BOUNDARY & TOPOGRAPHIC SURVEY  
 OF:  
 THE BAY HOUSE, PHASE II  
 NEWBURY/HANCOCK STREET  
 NEWBURY, MAINE  
 FOR:  
 113 NEWBURY STREET, LLC  
 35 FAY STREET, SUITE 107B  
 BOSTON, MA 02118-4320  
 TAB:EC

SHEET 2 OF 12

**BOUNDARY & TOPOGRAPHIC SURVEY**  
 OF:  
 SEAPORT LOFTS  
 NEWBURY / HANCOCK STREET  
 PORTLAND, MAINE  
 FOR:  
 113 NEWBURY STREET, LLC  
 35 FAY STREET, SUITE 07B  
 BOSTON, MA 02118-4920

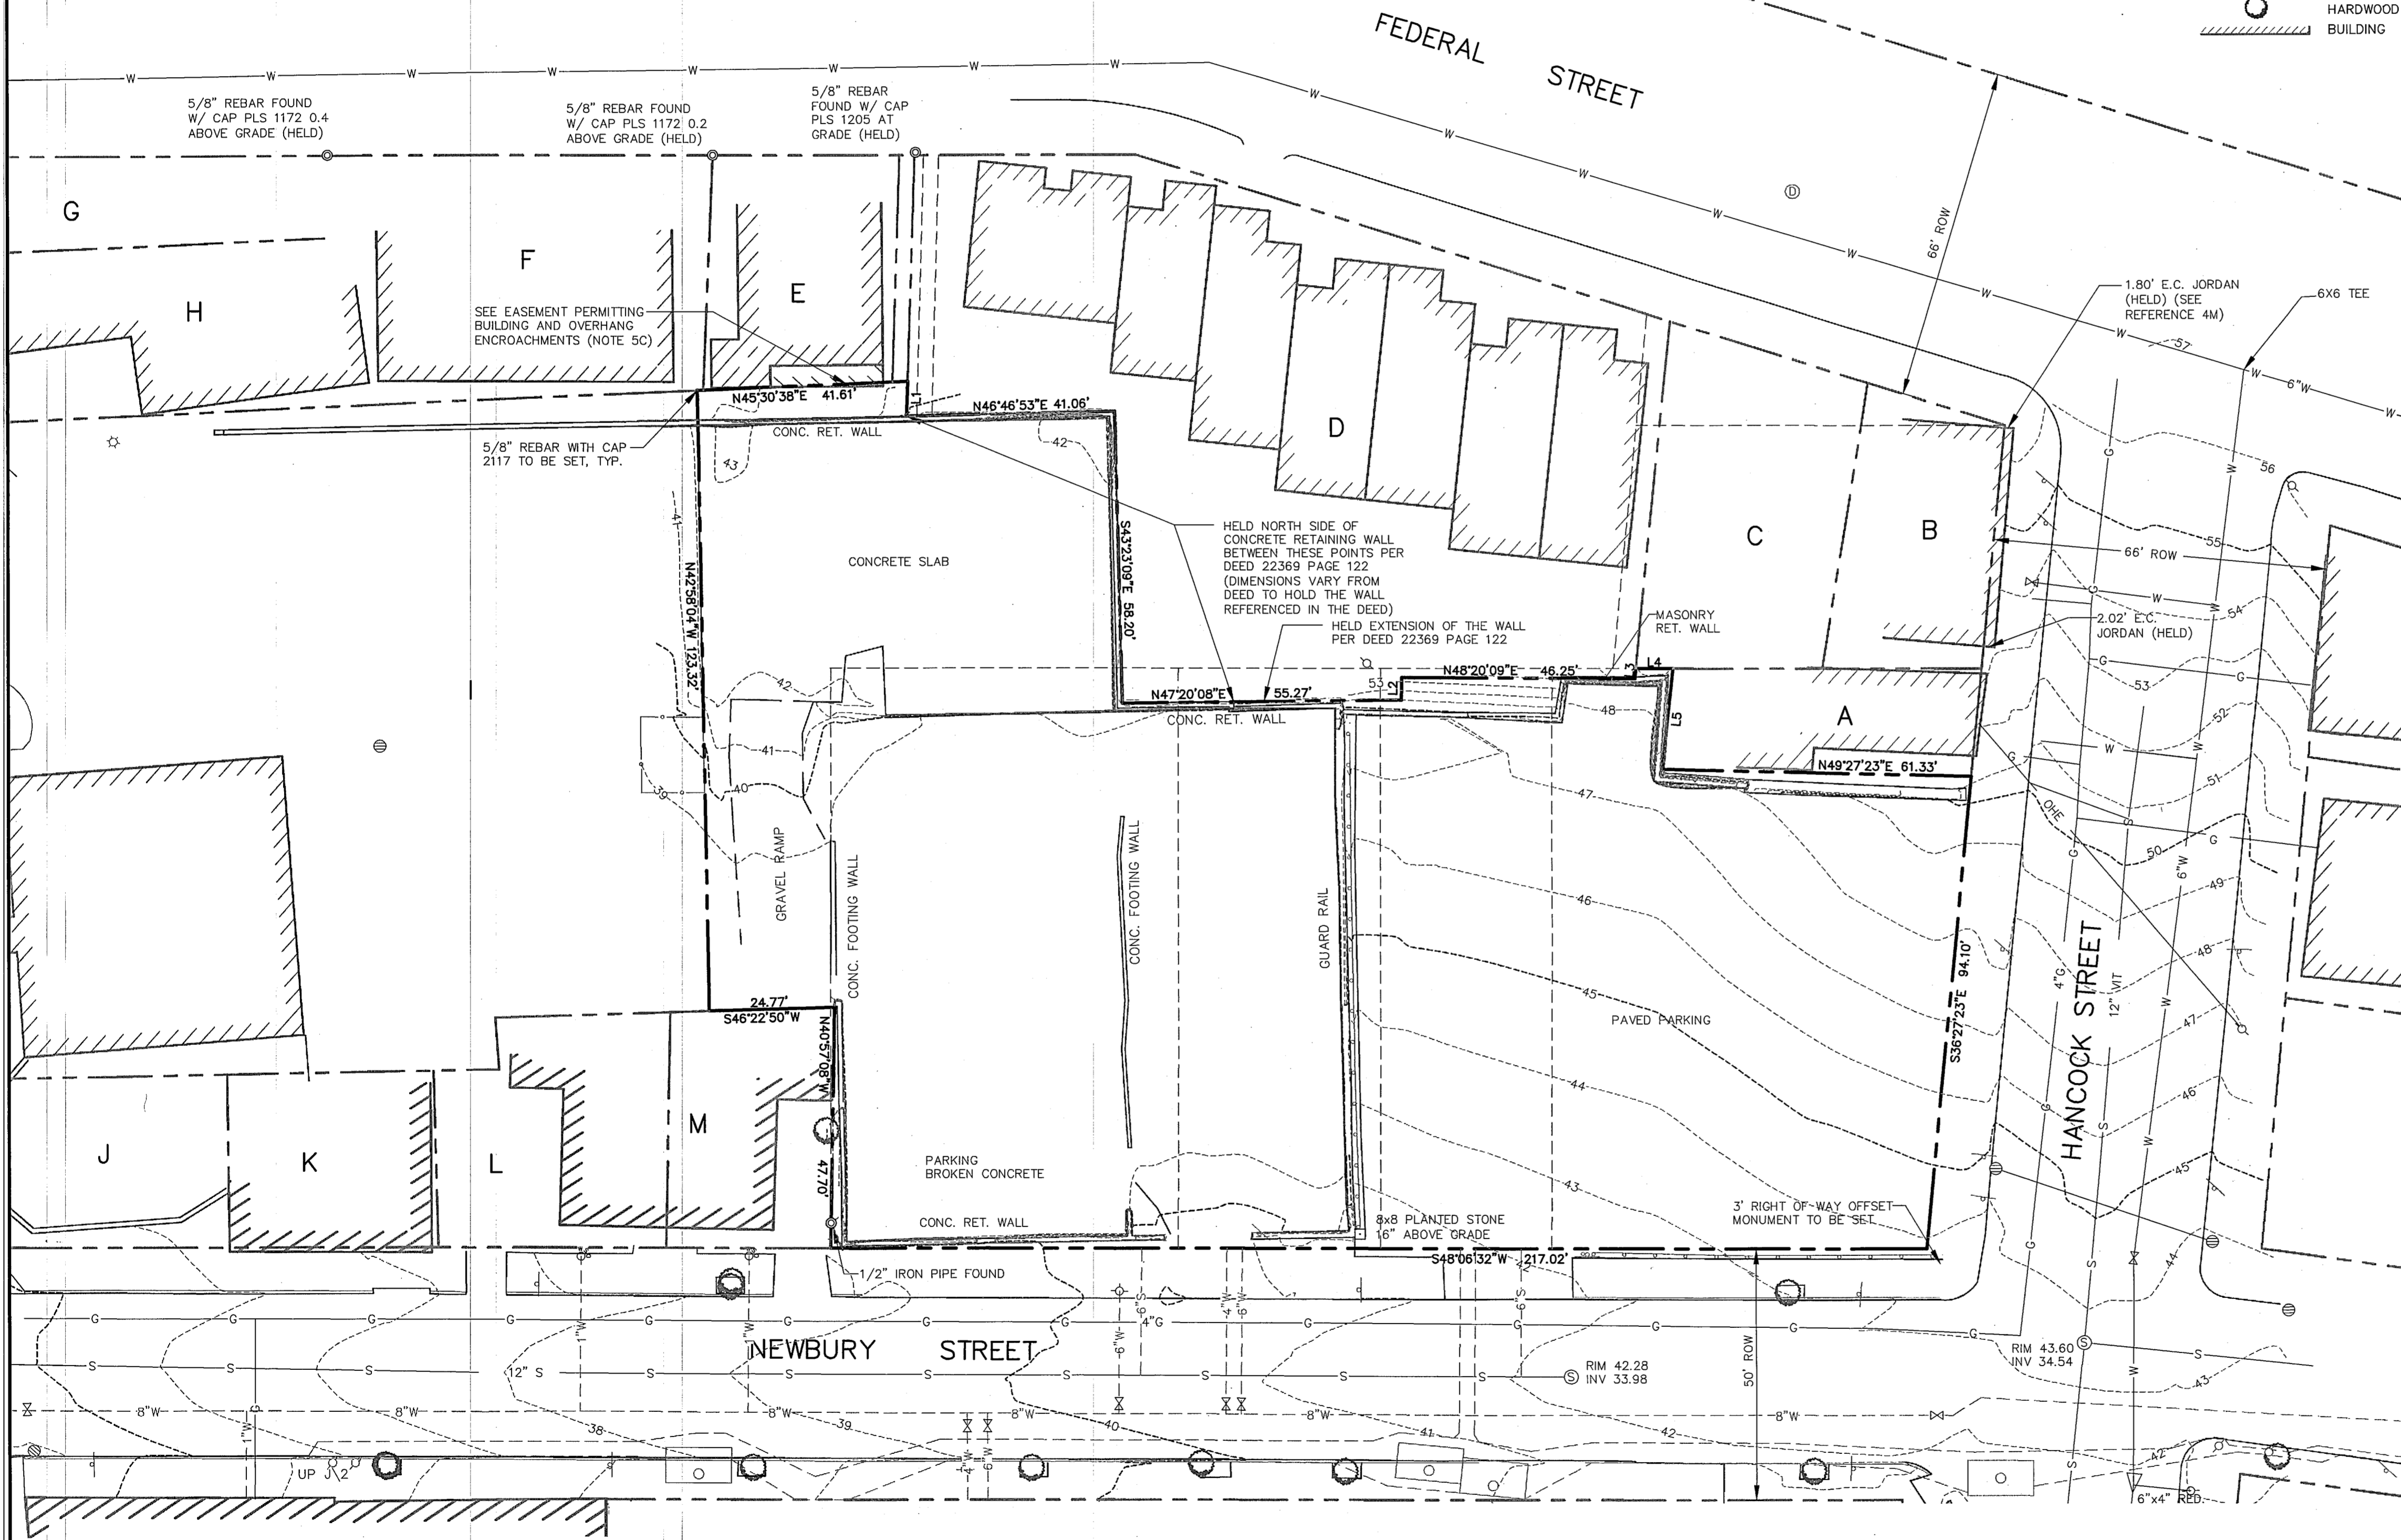
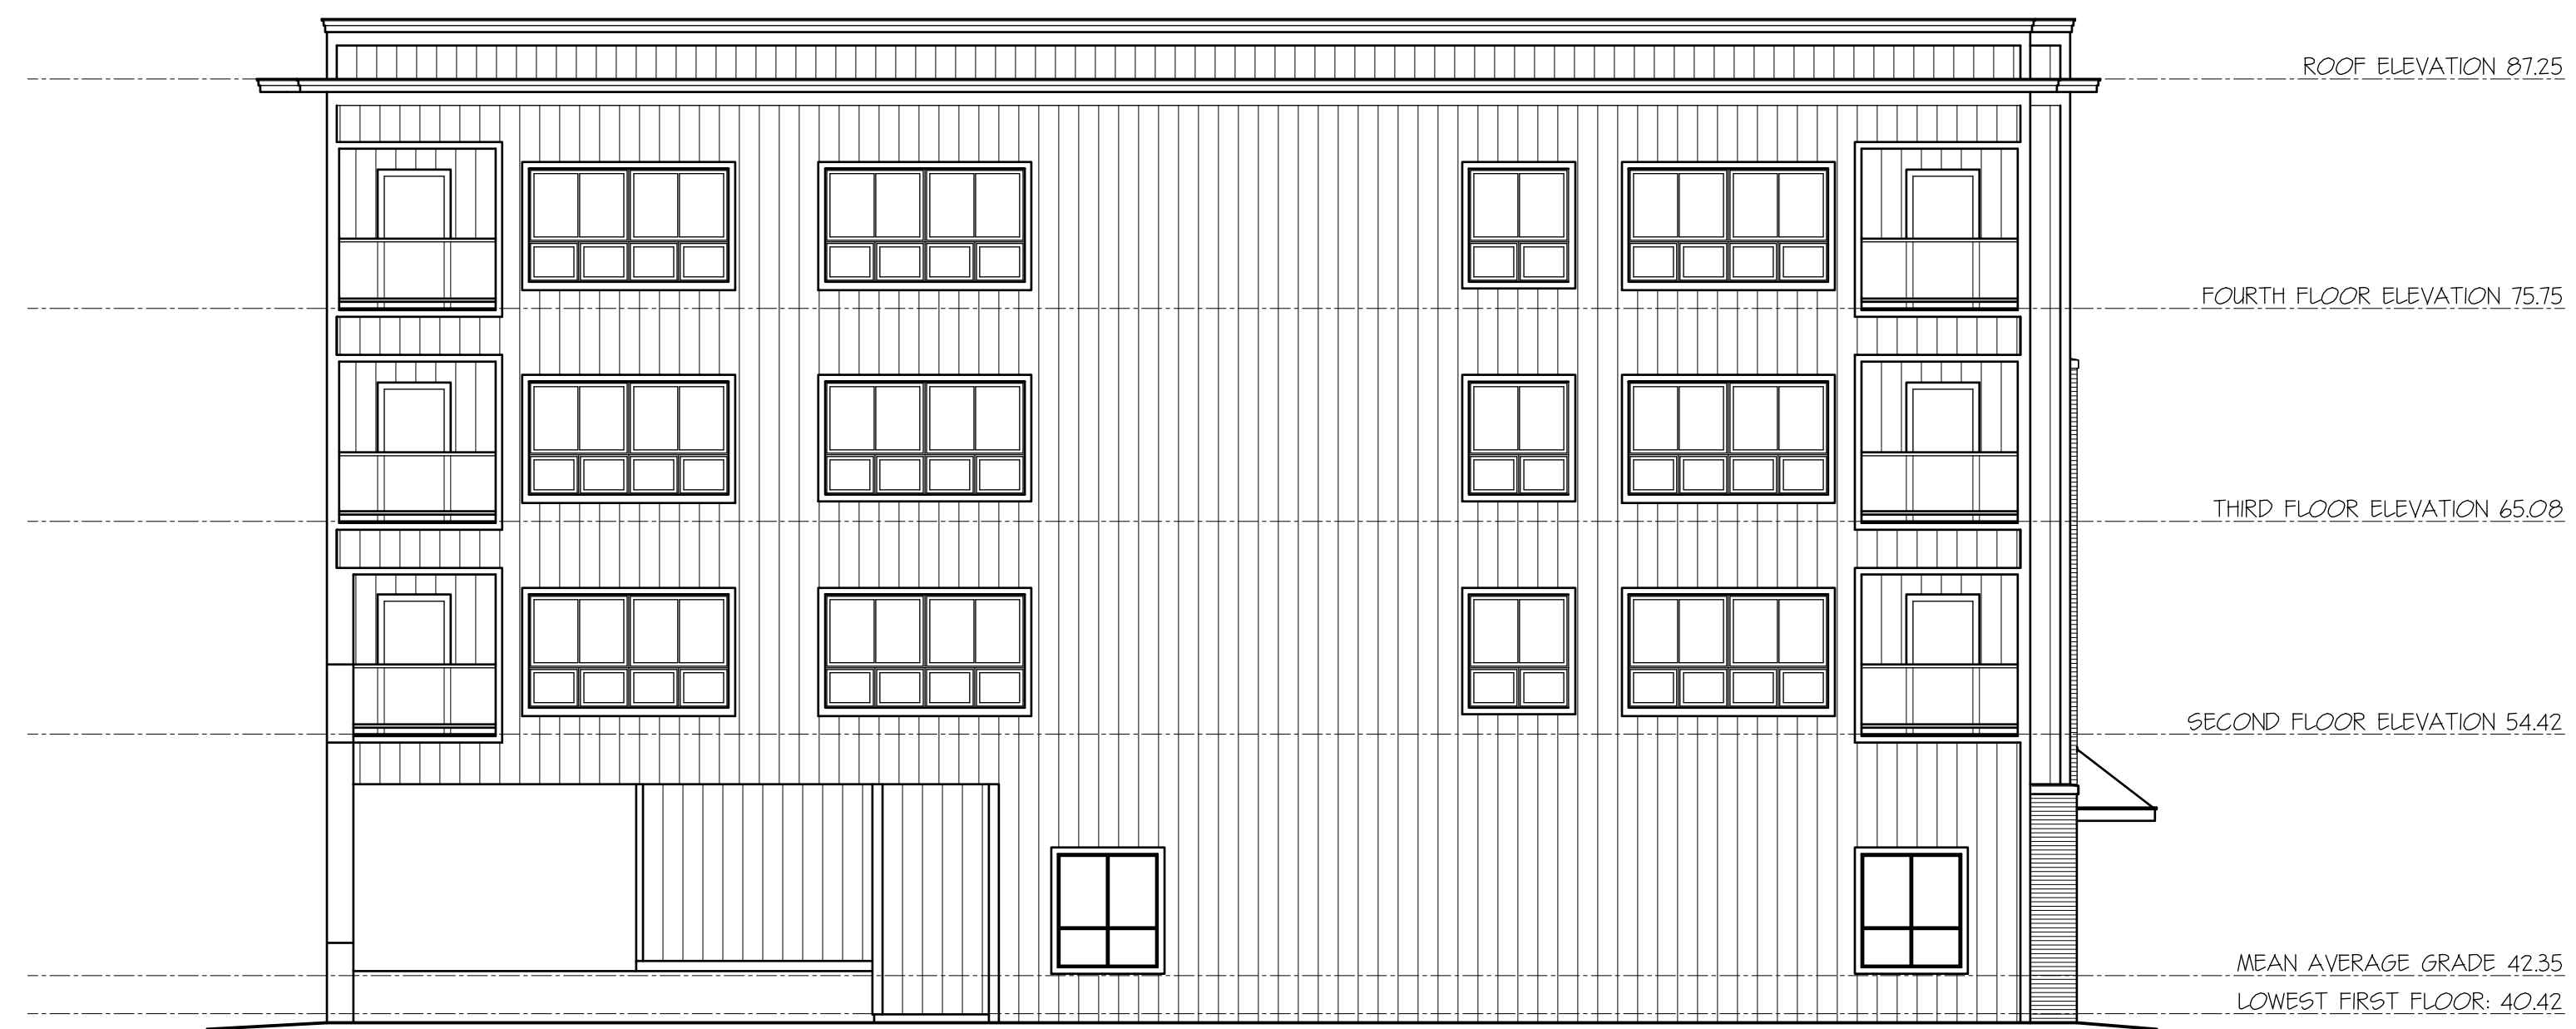
CONC. RET. WALL  
 THE CONCRETE RETAINING WALL ON THE 7/13/13 PLAN APPEARED TO BE ENTIRELY WITHIN CONCRETE SLAB  
 THE BOUNDARIES OF PHASE II - WHO IS RESPONSIBLE FOR WALL?  
 \* = DOES NOT MATCH 7/13/13 PLAN OF PHASE II WHICH INCLUDES PHASE I

PROPERTY CORNERS TO BE SET

- MONUMENT FROM PHASE I IS NOT SHOWN - SHOW STATE PLANE COORDINATES

SHOW STATE PLANE COORDINATES FOR PHASE I OFFSET MONUMENT AT MIDDLE ST. & HANCOCK ST.
